From: Debbie Farrell [REDACTED]
Sent: 06 September 2017 12:13
To: Simon Davis
Cc: Jessica Ferguson [REDACTED]
Subject: FP/161/17 - Tesco Store, Felpham - Variation of Condition

TESCO EXPRESS, BOGNOR REGIS
SITE PHOTOGRAPHS

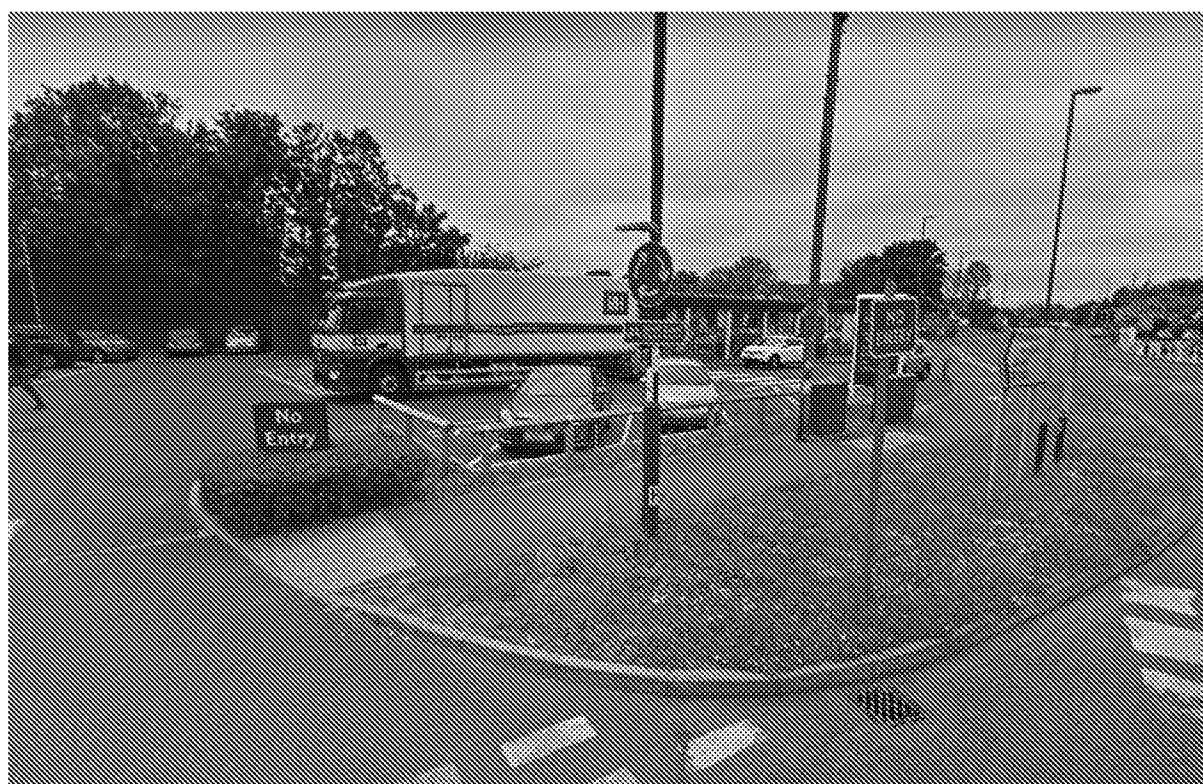
From the site visit photographs, it can be seen that manoeuvring in and out of the echelon spaces (in particular the two most easterly) spaces may be difficult for vehicles other than a small car type when deliveries are taking place. In addition, the westerly space results in vehicles reversing onto the pedestrian crossing. Whilst these manoeuvres are possible and could be shown with a traffic plot on a plan, they do appear to be limited and likely result in vehicles waiting at or close to the access for a prolonged period.

The photographs also show vehicles parked in areas within the site which are not parking spaces i.e. on either side of the access. It is appreciated that this is a decision made by drivers and difficult to manage however it is argued that this type of parking will continue to occur and does have an impact on the application.
